# KITITAS COUNTY

### MEMORANDUM

DATE: November 14, 2012

SUBJECT: Sasse Ridge Plat LP-11-00002

SASSE RIDGE PLAT
A PORTION OF THE WEST 1/2 OF SECTION 21,
TOWNSHIP 21 NORTH, RANGE 14 EAST, W.M.
KITITAS COUNTY, STATE OF WASHINGTON

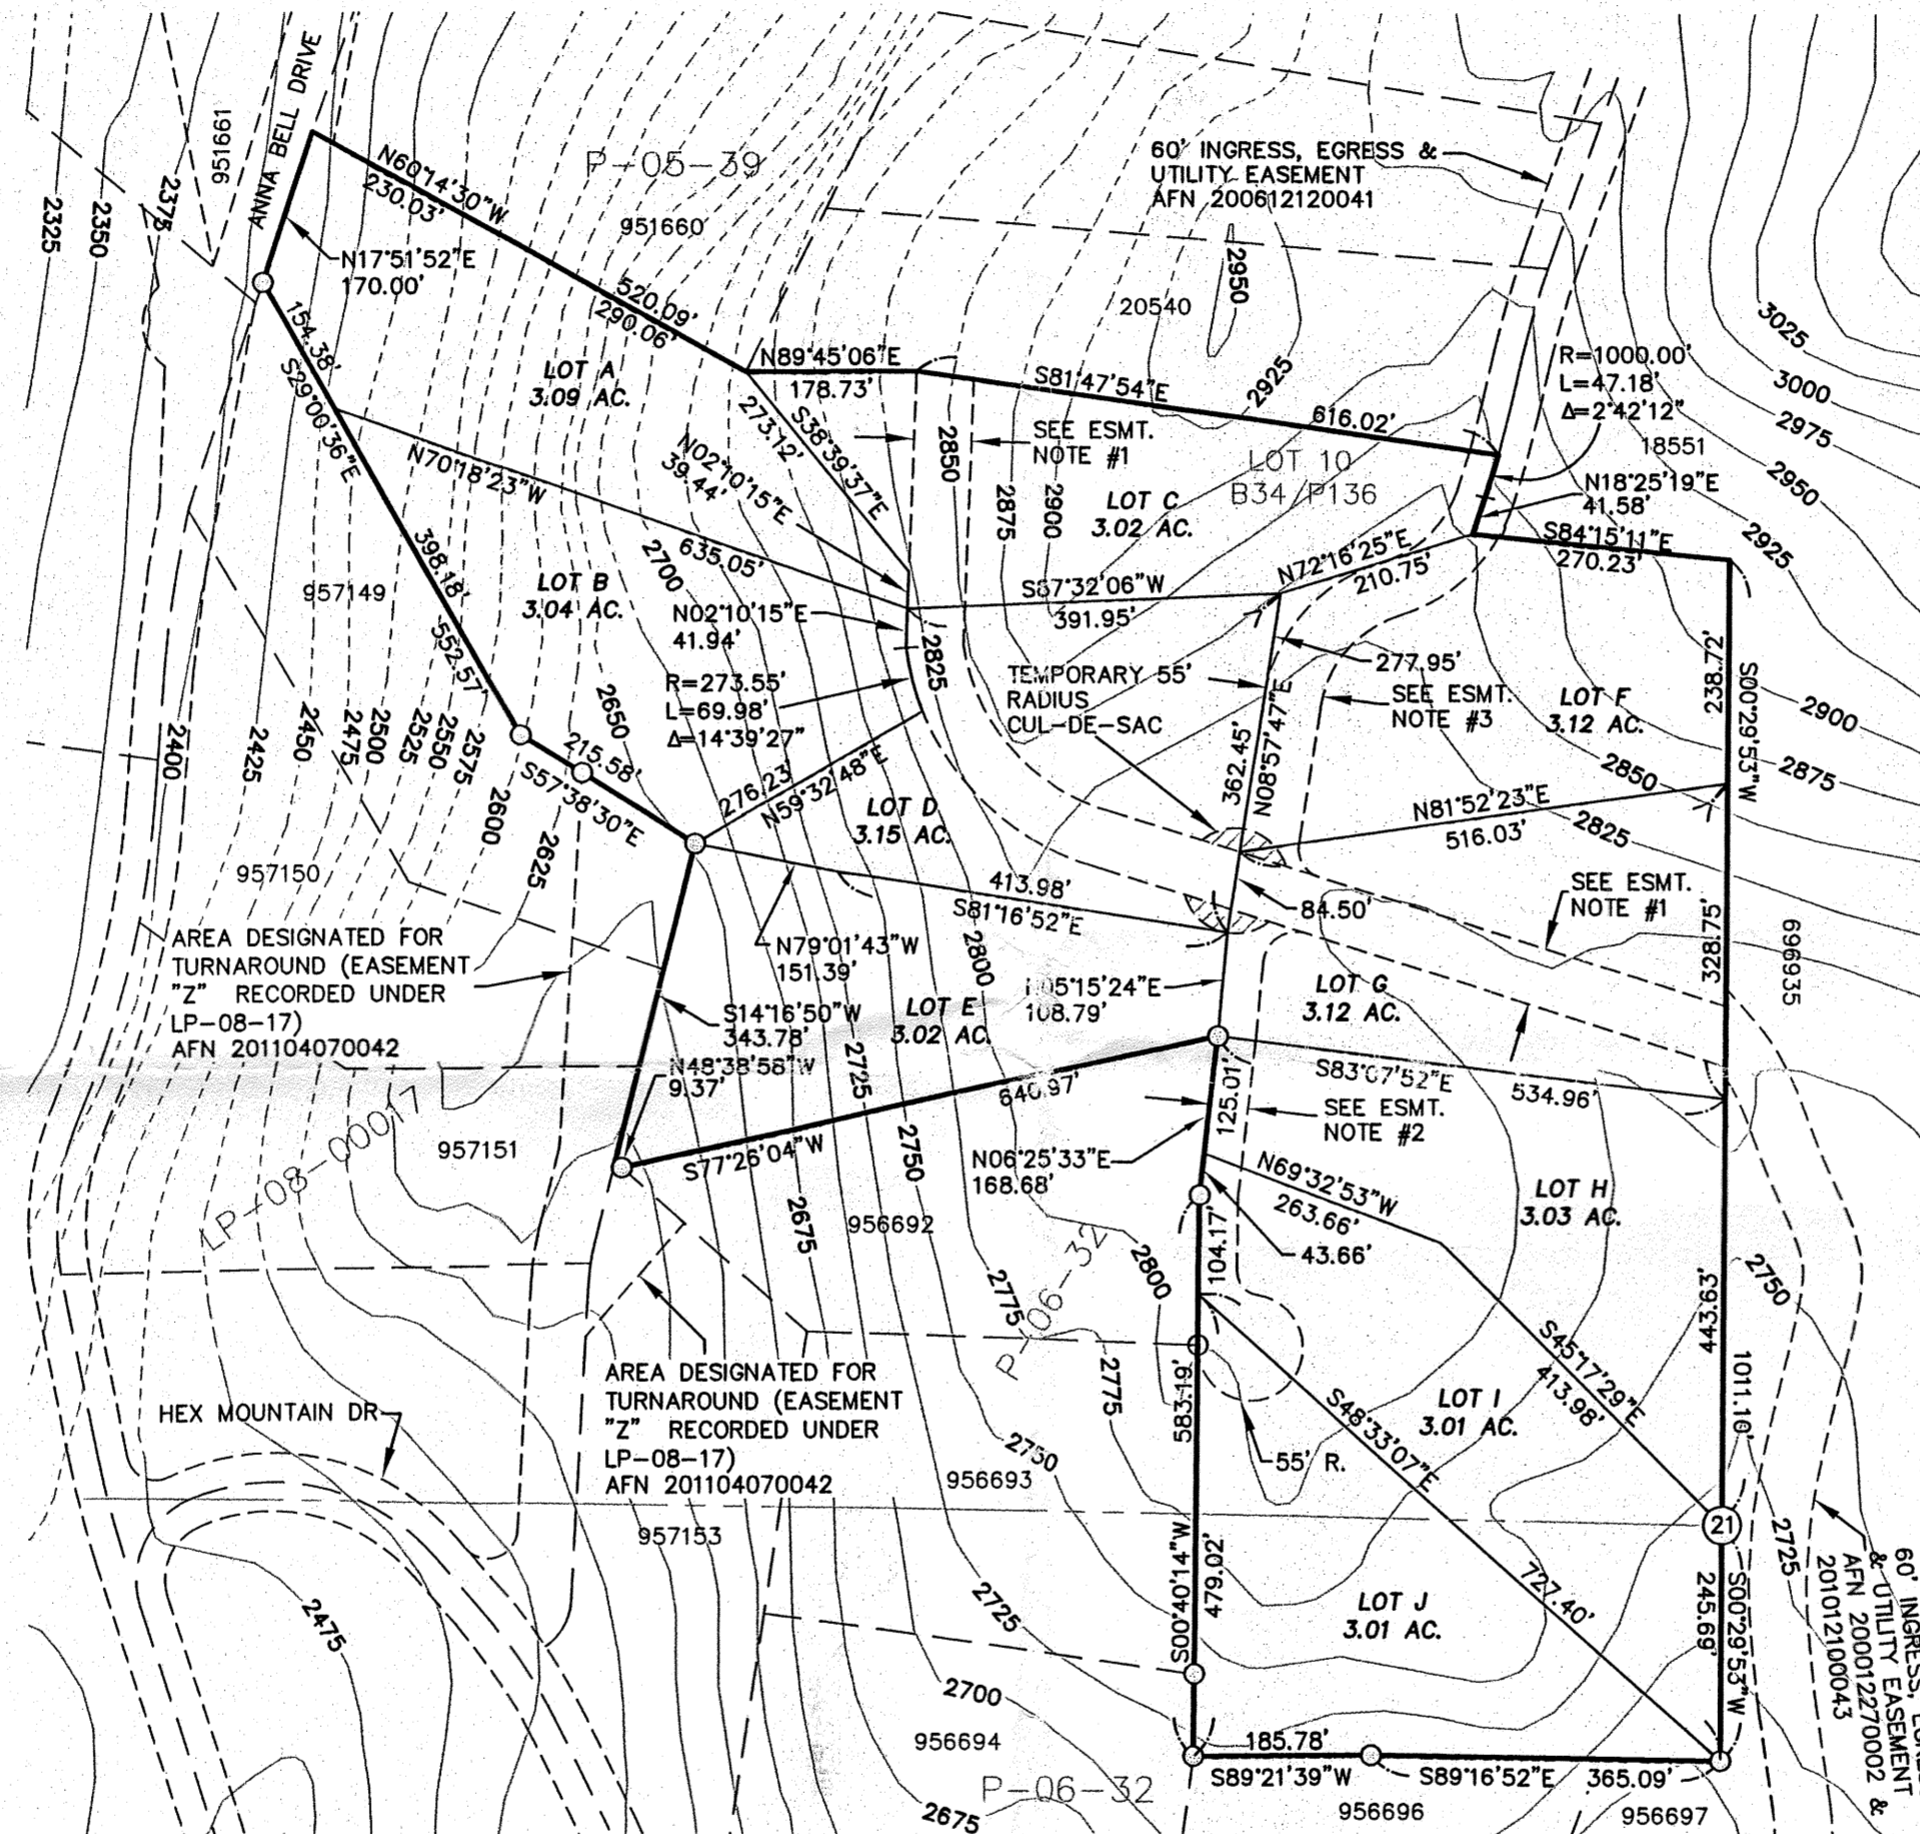
3. Private Road Improvements: Access shall be constructed to meet or exceed the conditions of a High-Density Private Road that serves 15-40 tax parcels. See current Kittitas County Road Standards, 9/6/05 edition.

- a. Access easements shall be a minimum of 60' wide. The roadway shall have a minimum width of 22', with 1' shoulders, for a total width of 24'.
  - b. Minimum centerline radius shall be 60'.

4. Temporary Cul-de-Sac: No more than two lots can be served off a cul-de-sac. Prior to final approval, individual lot accesses shall be determined to ensure the temporary cul-de-sac is placed appropriately.

5. Cul-de-Sac: A cul-de-sac turn-around having an outside right-of-way or easement diameter of at least 110 feet shall be constructed at the closed end of all dead-end roads serving 3 or more lots. The driving surface shall be at least 96 feet in diameter. Cul-de-sacs must also conform to the requirements specified by the 2009 International Fire Code. Contact the Fire Marshal regarding any additional cul-de-sac requirements.
